Rezoning Transportation Analysis
Petition Number: Insert Zoning Petition #2021-045
General Location Identifier: Tax ID 02918118

Revision Log:

Date	Description
04-29-21	First Review (EL)

REZONING PETITION #2021-045
FOR
MALLARD CREEK APARTMENTS
CHARLOTTE, NORTH CAROLINA

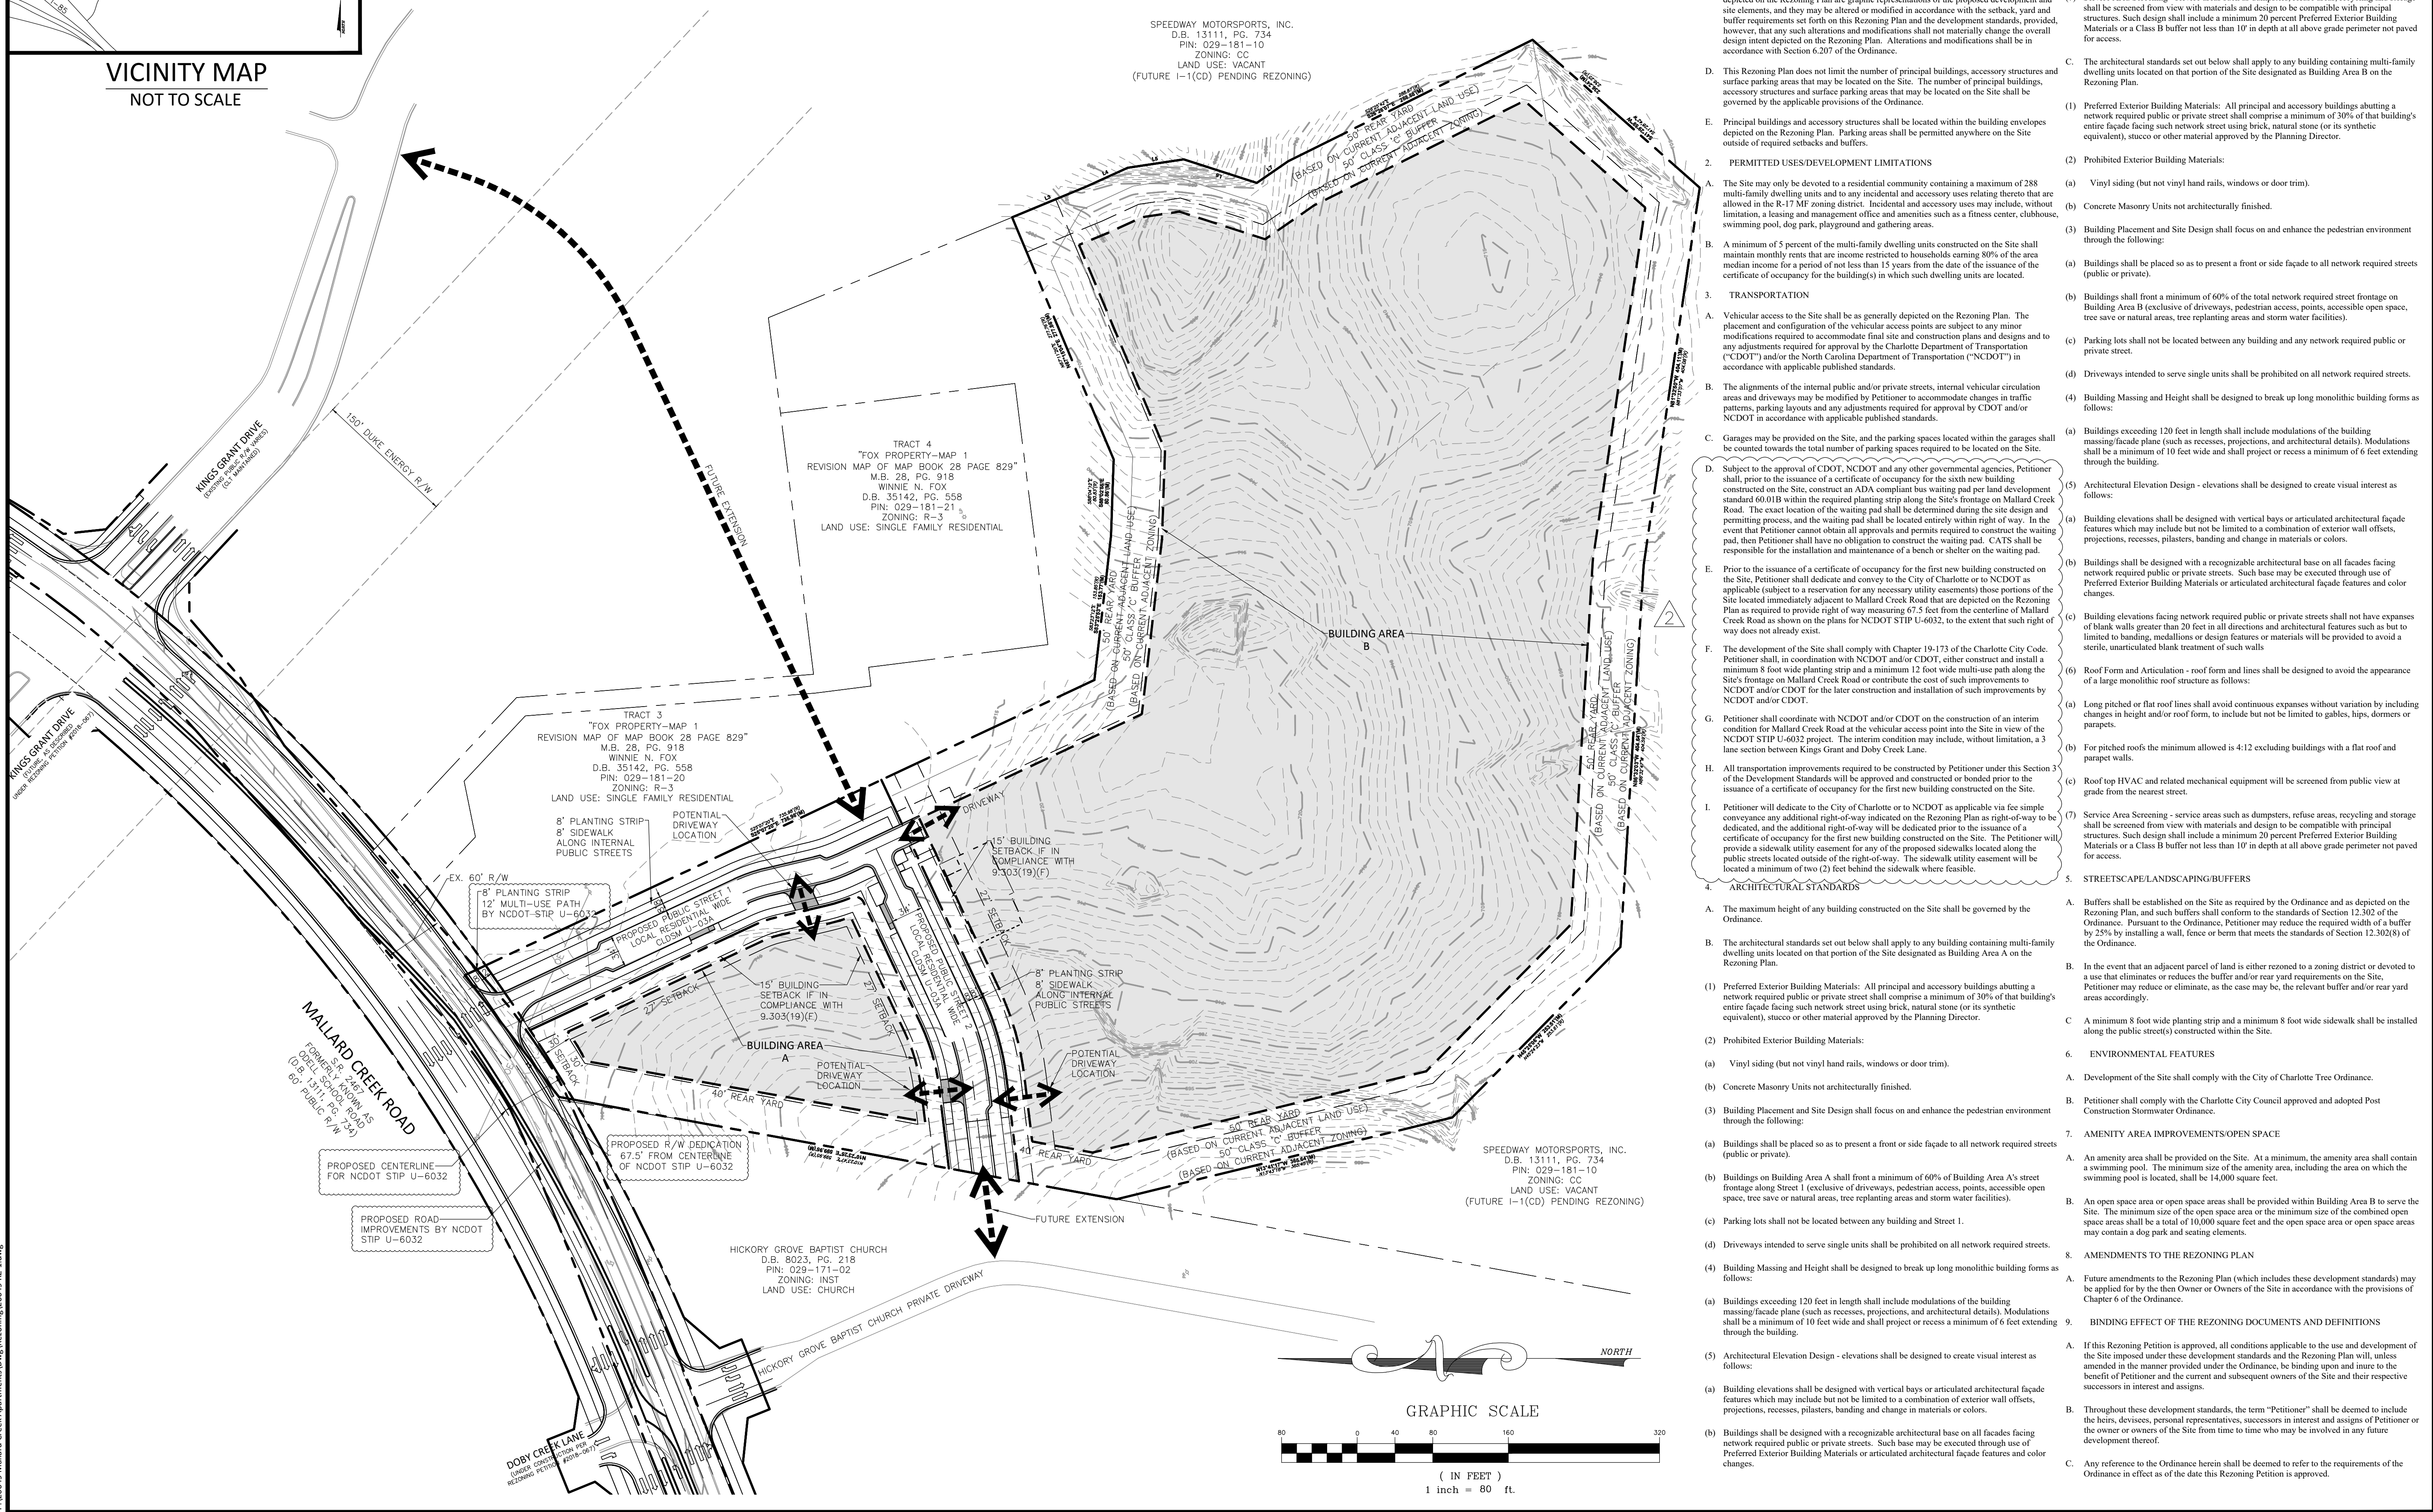
- a. **Mallard Creek Road:** The future location of curb and gutter is shown below, 46 feet to the future back of curb from road centerline, per the 75% design plans for the NCDOT STIP U-6032 Mallard Creek Road widening project. Coordinate with NCDOT to coordinate this rezoning with the STIP project.

Label and dimension the curb and gutter from the centerline for each road on the site plan.

3. Revise site plan and conditional note(s) to commit to dedicate 67.5-feet of public right-of-way plans for the NCDOT STIP U-6032 Mallard Creek Road widening project, measured from the Mallard Creek Road centerline. The site plan shall label and dimension the right-of-way from the road centerline.

4. Revise the site plan and conditional note(s) to specify that this petition will comply with Chapter 19-173 of the City Code. Coordinate with NCDOT and CDOT to determine if the 8-foot planting strip and 12-foot multi-use path that is proposed within the NCDOT STIP U-6032 Mallard Creek Road widening project will be constructed as part of this land development project, or if the petitioner will commit to a contribution per Chapter 19-173(f)(1,2). The site plan needs to label and dimension both items from the future back of curb and gutter and road centerline.
5. The proposed dwelling units exceeds 12 per acre. Per Chapter 20 Subdivision ordinance, site plan and conditional note(s) revisions are needed to commit to construct an 8-foot planting strip and 8-foot sidewalk along the proposed internal public streets. The wider sidewalk also meets the Charlotte WALKS Council-adopted Policy.

6. Revise the site plan and conditional note(s) to widen Mallard Creek Road to a continuous 3-lane section for an interim full-movement access, to provide a left-turn lane into the proposed internal street network. The widening limits are specified below. Specify that these road improvements will be designed in accordance with NCDOT standards.

CDOT and NCDOT support widening for an interim 3-lane section between Kings Grant and Doby Creek Lane. The proposed access will be permitted as full movement in the interim, but would be restricted to RI/RO when the future NCDOT STIP is constructed

7. A site plan note(s) specifying dedication and fee simple conveyance of all rights-of-way to the City before the site's first building certificate of occupancy is issued is needed. CDOT requests rights-of-way set at 2' behind back of sidewalk where feasible.
8. A site plan note specifying that all transportation improvements will be approved and constructed before the site's first building certificate of occupancy is issued is needed. The petitioner may phase transportation improvements if said improvements and phasing are explicitly described in site plan notes.
